File Ref: 20/060
MP 10_0137 MOD 14

**Submission to Modification in respect to
Huntlee New Town (MP 10 0137 MOD 14)**

I refer to the above notification received from the Planning, Industry and Environment Department 2 September 2020. The following submission is offered by Mr PD Vizzard, in respect to the above modification.

Figure 3 Required APZ for the large lot site

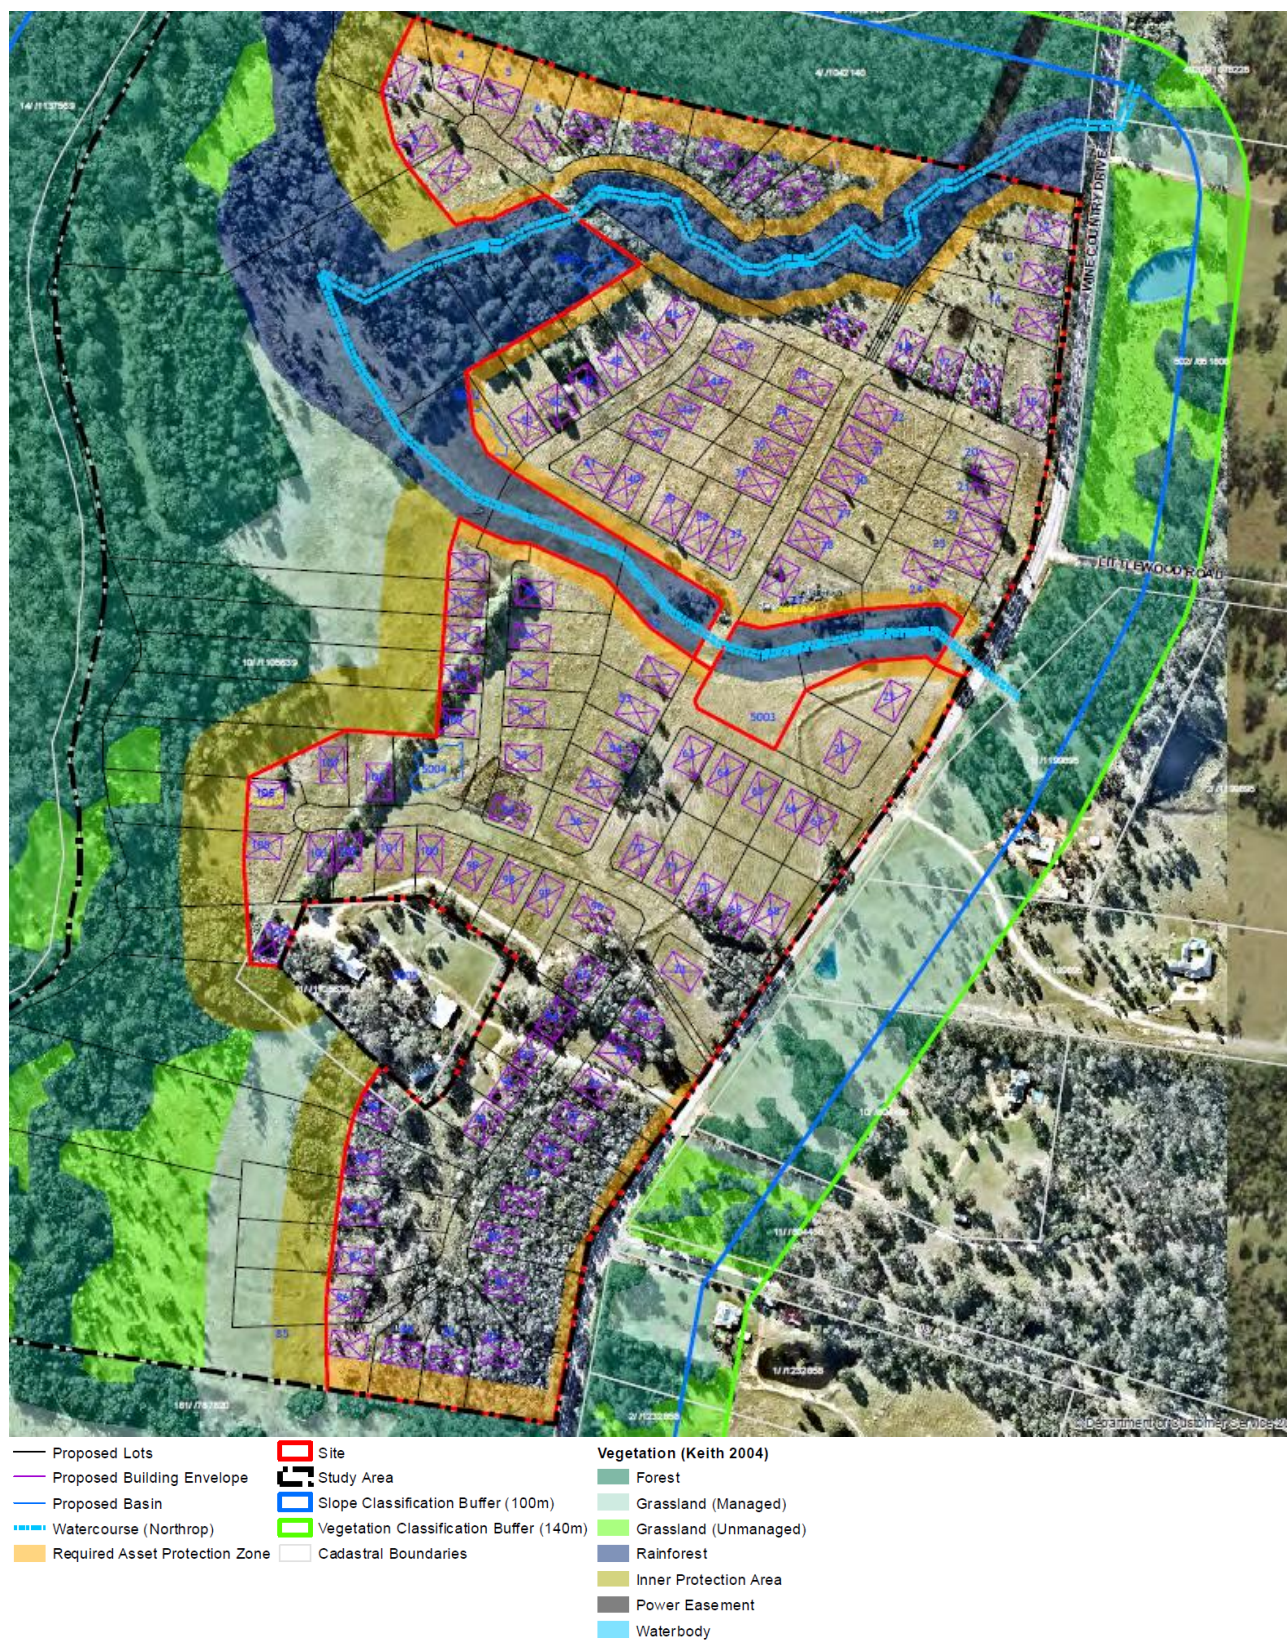
The original design, as it pertains to the northern boundary, appears like that originally proposed, however the Act has been amended to place greater emphasis on the provision of perimeter trails. The bushfire attack rating for housing in this area is high and there is only one Cul-de-Sac leading in and out which may be longer than 200m. This access also crosses a heavily timbered drainage line which creates a bushfire risk on all sides of dwellings in this location.

The provision of a perimeter trail road or road should be considered along the northern boundary as the adjoining property, to the north, and will never be developed due to its environmental value, thus promoting its continued state of dense bushland.

DRAWING TITLE: **1 TO 3000(MOD14)**
 PROJECT: **HUNTLEE STAGE 1 - DEVELOPMENT AREA WINE COUNTRY DRIVE, HUNTLEE**
 CLIENT: **HUNTLEE PTY.LTD.**

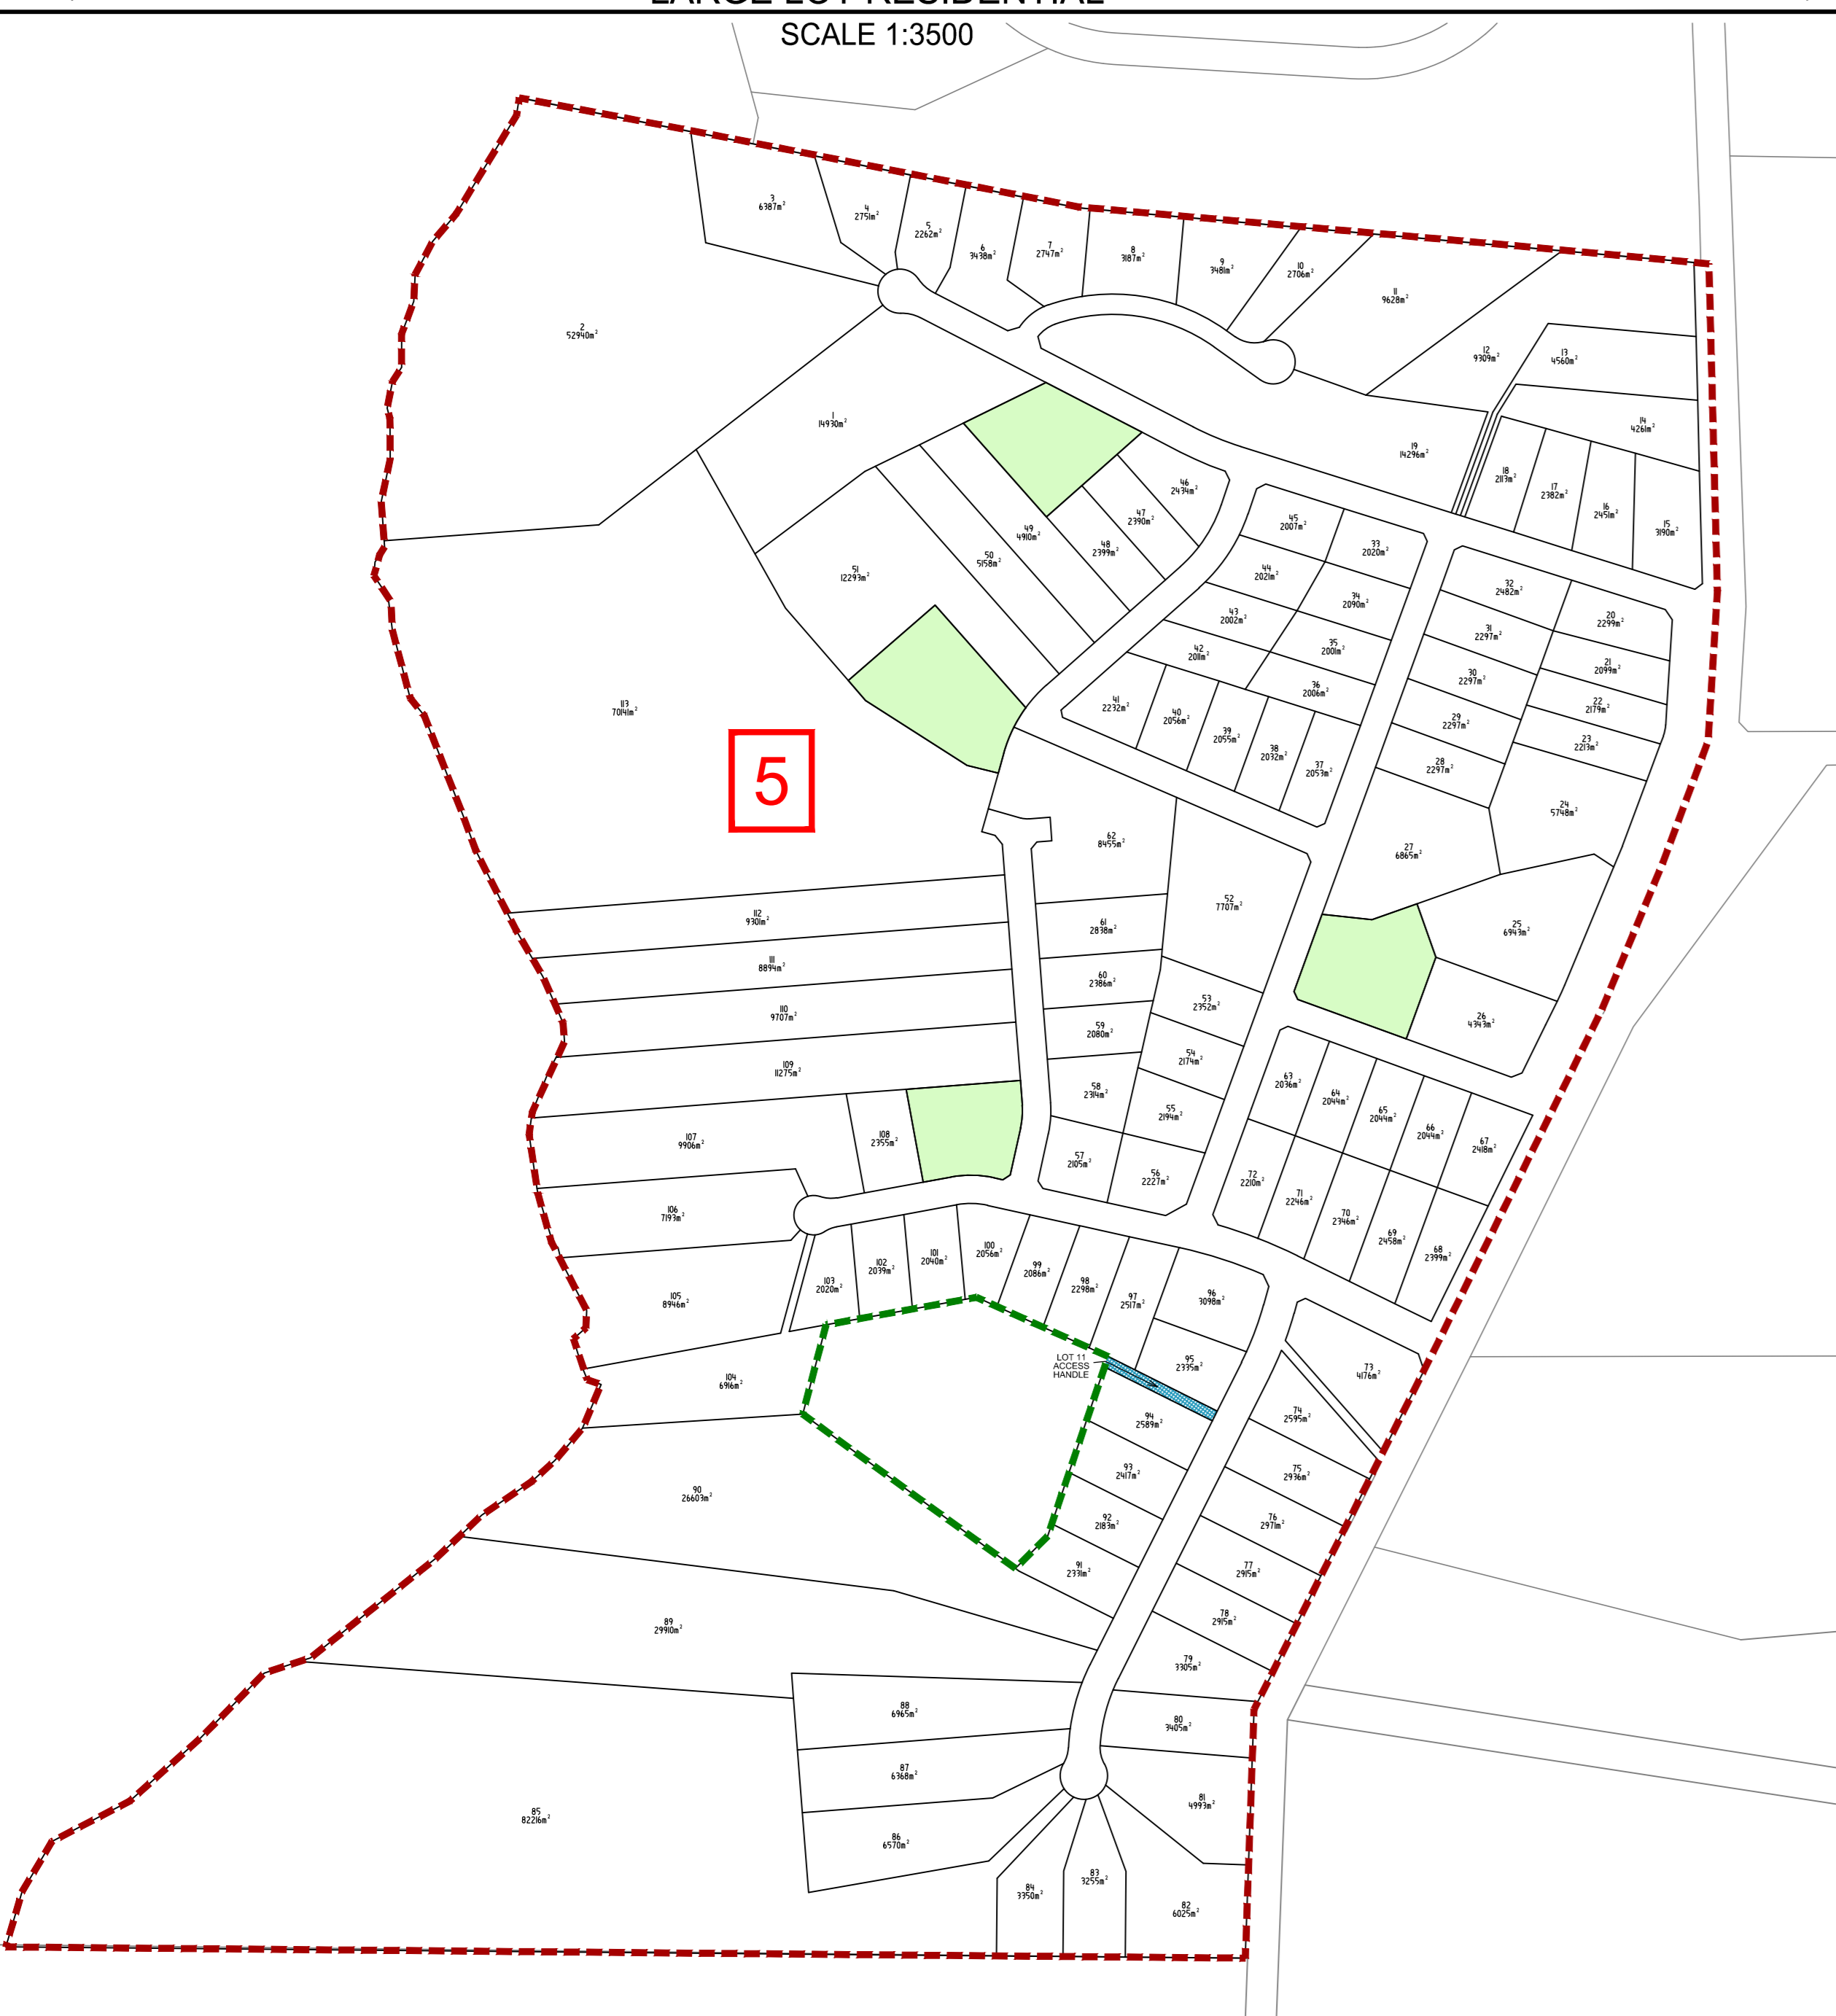
The current lot layout as proposed in MOD14 should be amended to provide for the future development of Mr Vizzard's land (Lot 11) as shown in the attached plan.

Lot 11, currently owned by Mr Vizzard, is capable of being developed as Large Lot Residential in accordance with the attached plan. Failure to provide for this in proposed MOD 14 would represent an underutilisation of the area and be contrary to the following objective of the *Environmental Planning and Assessment Act 1979*.

The revised design seeks to remove the previously identified Endangered Ecological Communities (EEC) located on the south eastern section which was previously left as bushland. The current design shows this area to be totally replaced with housing.

Justification for the removal of the EEC in the south eastern corner has not been provided and should be. Its removal is also objected to, as it currently acts as a buffer for traffic noise on Wine Country Drive. Due to the proximity of critically endangered flora it is considered that it may be more appropriate to maintain a buffer on the northern edge of the development.

Council 1% AEP Flood Depth and Extent

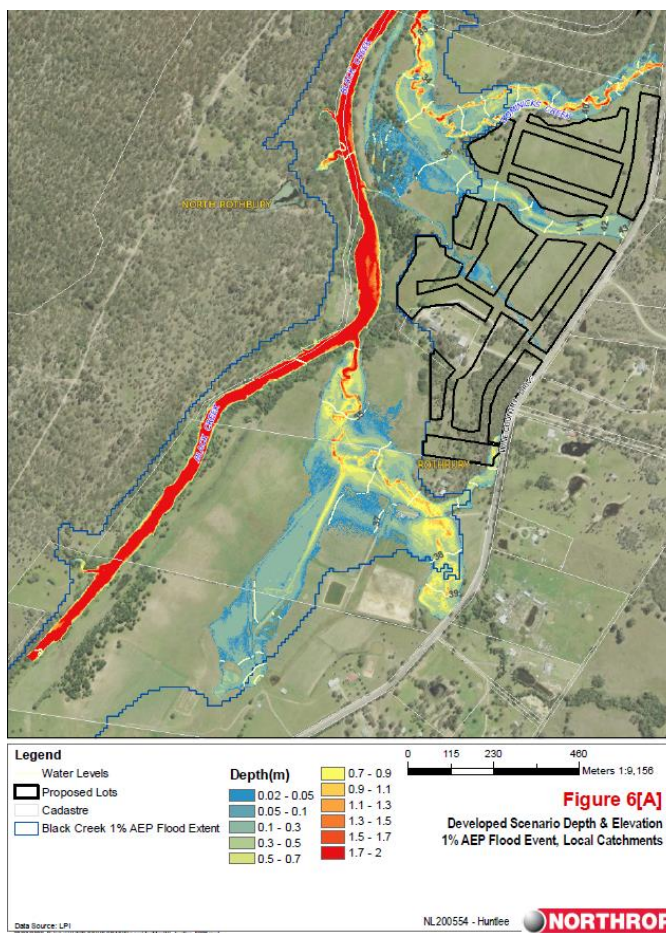
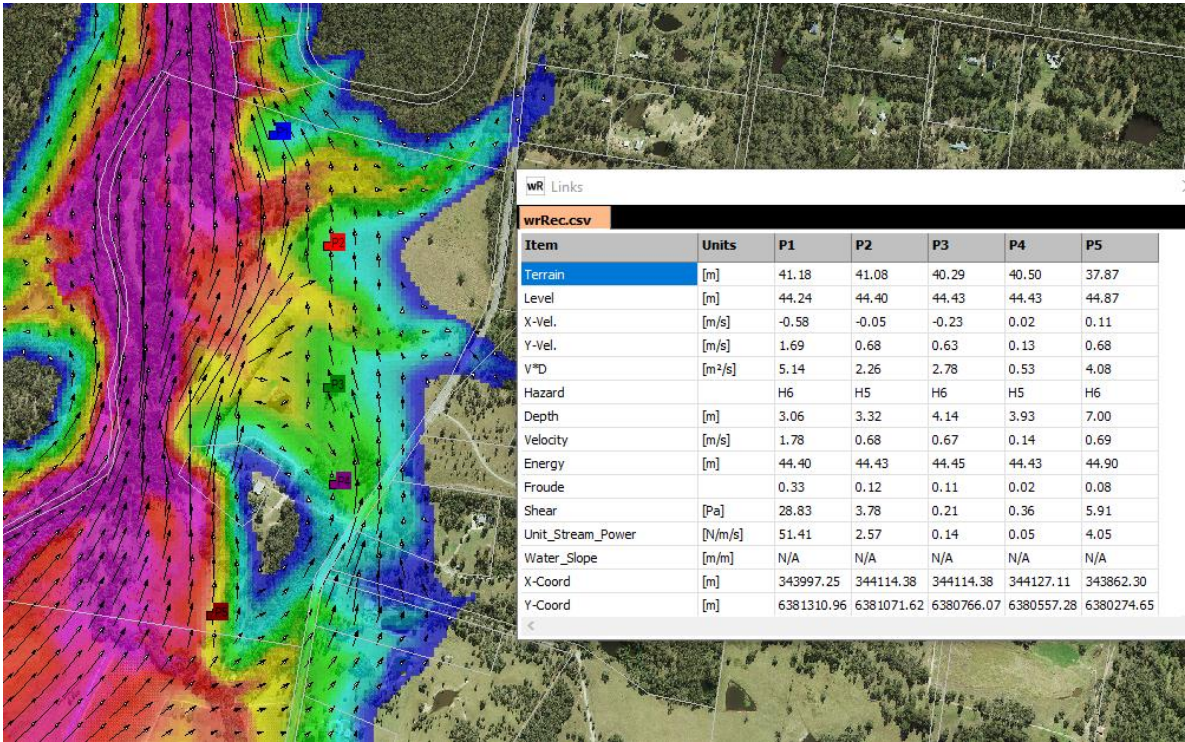
Mr Vizzard is a longtime resident of this site and has regularly recorded flood events up to his boundary. The flood study shows flood levels lower than experienced on this site. Water also flows across Wine Country Drive from the east and adequate protection is required for the existing drainage lines.

Further protection in the way of the easements or drainage reserves should be established over the existing Category 2 drainage lines, and the flood study should be revised.
